Consultation Response from: KC Environmental Health (Pollution & Noise Control)		
2020/92331 Land east of, Leeds Road, Chidswell, Shaw Cross, Dewsbury		
Outline planning application for demolition of existing dwellings and development of phased, mixed use scheme comprising residential development (up to 1,354 dwellings), employment development (up to 35 hectares of B1(part a and c), B2, B8 uses), residential institution (C2) development (up to 1 hectare), a local centre (comprising A1/A2/A3/A4/A5/D1/D2 uses), a 2 form entry primary school including early years provision, green space, access and other associated infrastructure		
Date Responded: 16 October 2020	Responding Officer: Rebecca Muff (Air Quality & Odour) Natalie Heaney (Land Contamination) Mohammed Nasim (Noise) & Richard Hume	Responding Ref: WK/202021975
<p>Air Quality An Air Quality Assessment has been completed by Redmore Environmental Ltd and appears in Volume 1, Chapter 10 of the Environmental Statement by Deloitte Real Estate dated March 2020. The Environmental Statement is in support of an outline application for up to 1,354 houses, a commercial centre and a primary school.</p> <p>The Air Quality Assessment classifi

Figure:	Figure 9. 2		
Title:	Measured time history (1hr resolution) at LT1		
Project:	Leeds Road, Chidswell		
Date:	26/02/20	Scale:	None

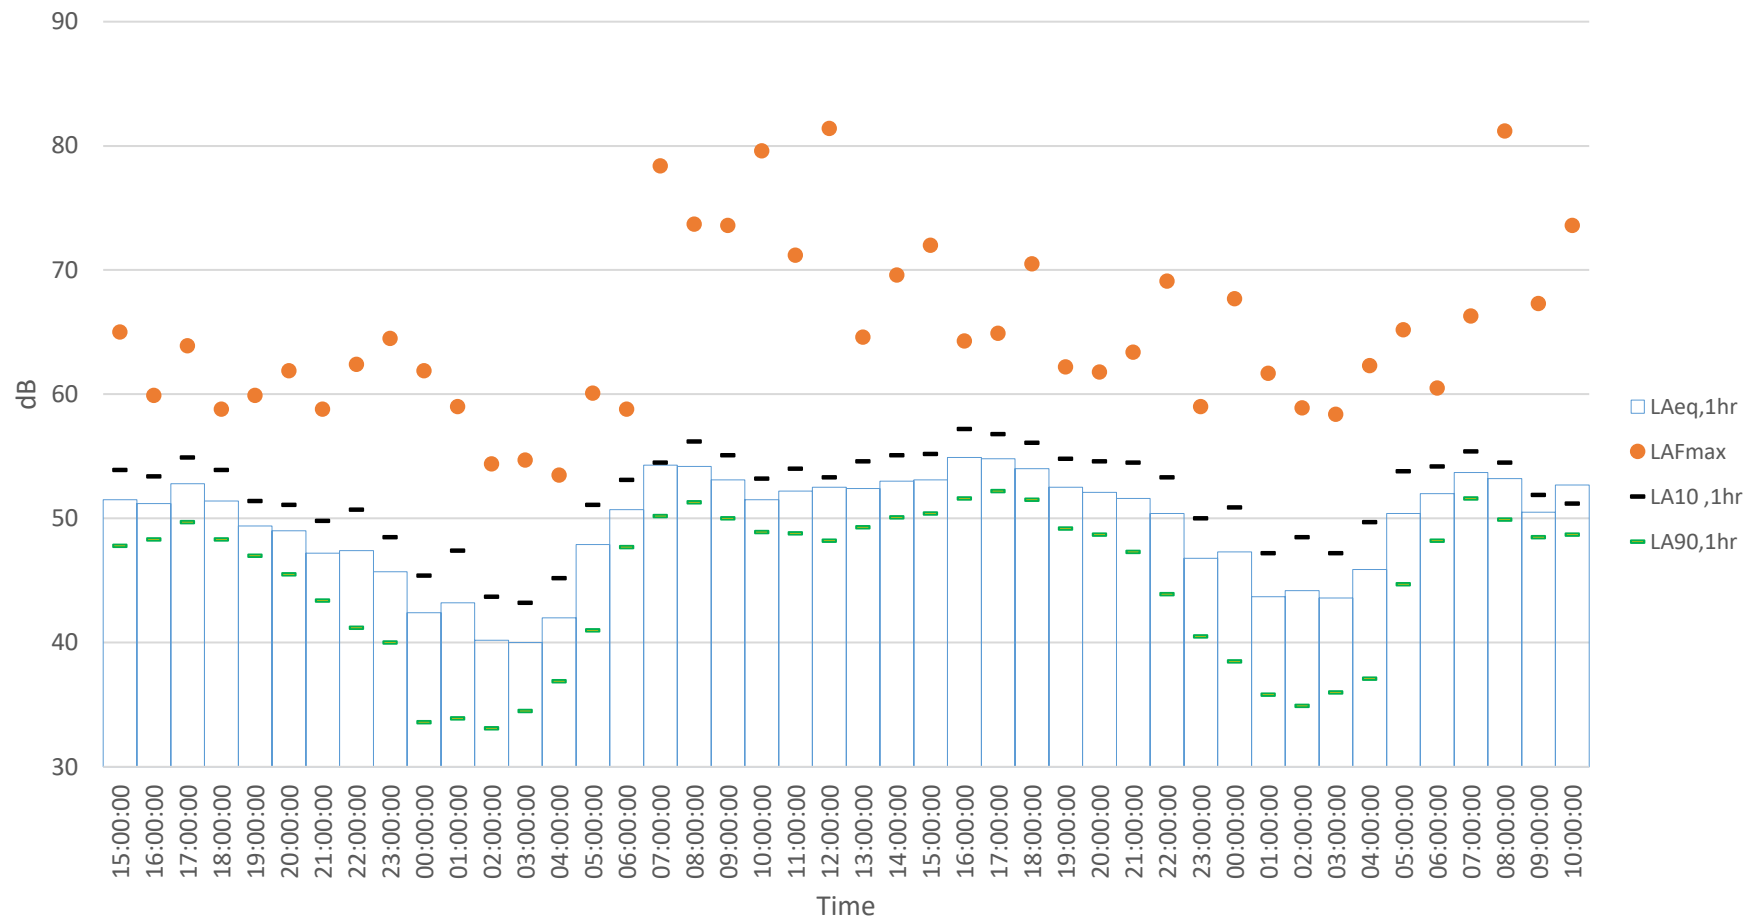
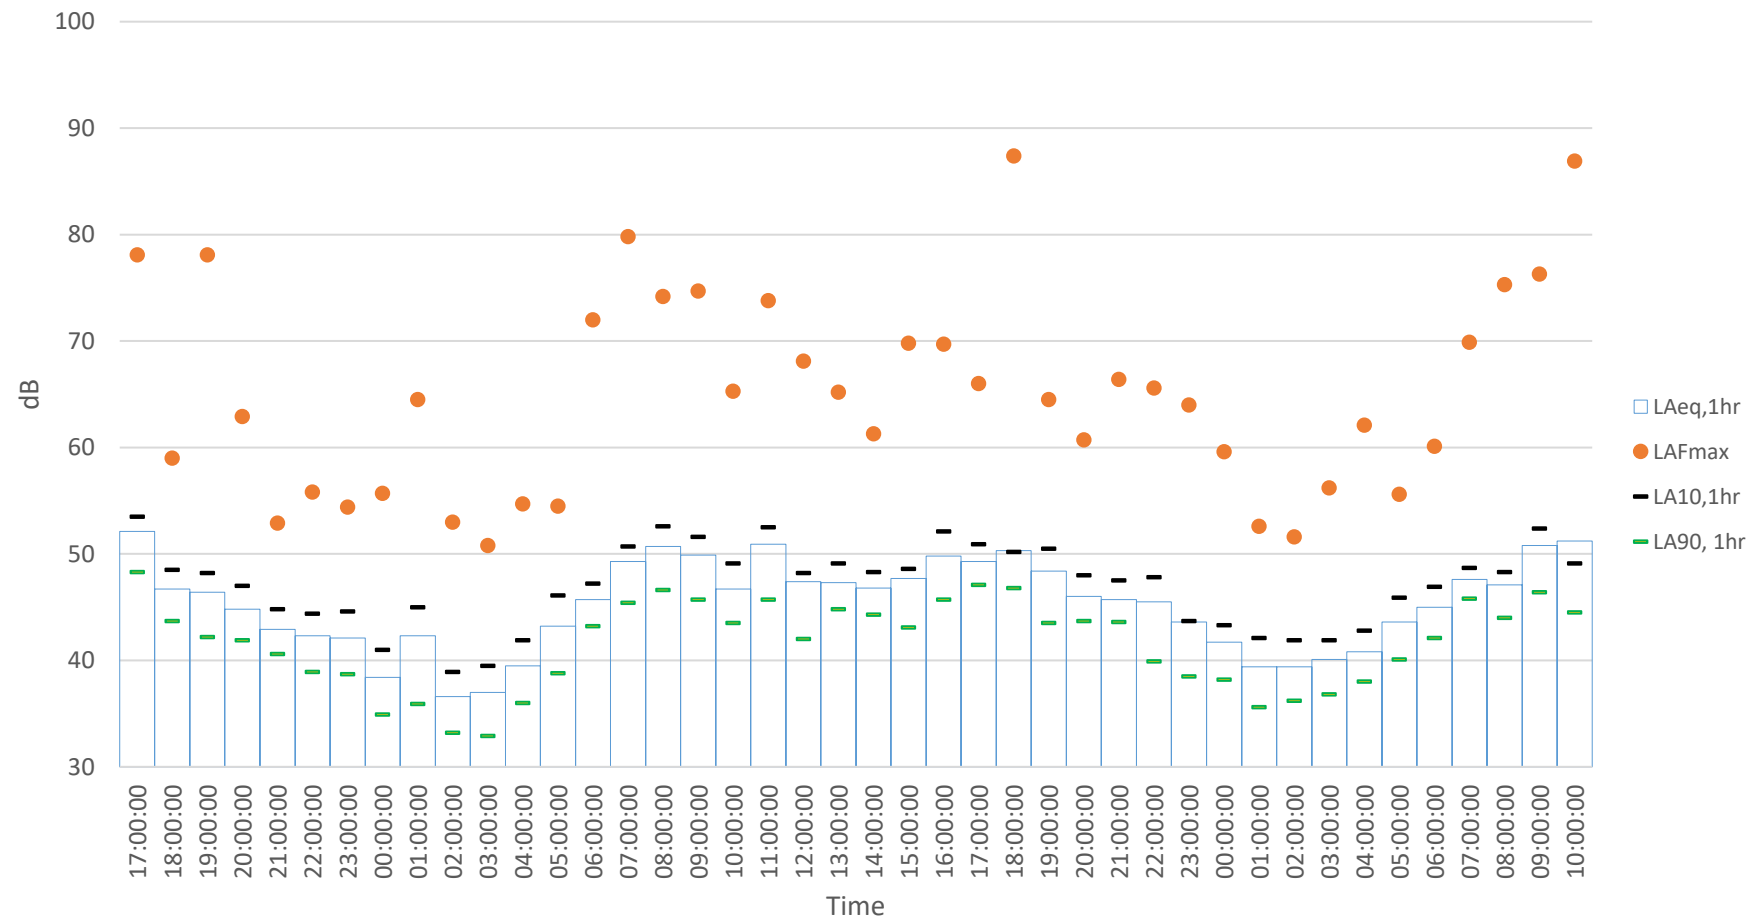
LT monitoring was carried out on Weds 23 October 2019 until 24 October 2019 and reference is made to this in figures 9.2 and 9.3. However, Figures 9.2 and 9.3 show monitoring started at 1500hrs, through a full 24hr cycle until 1000hrs two days later and this timeframe of 44hrs does not tie in with the above dates.
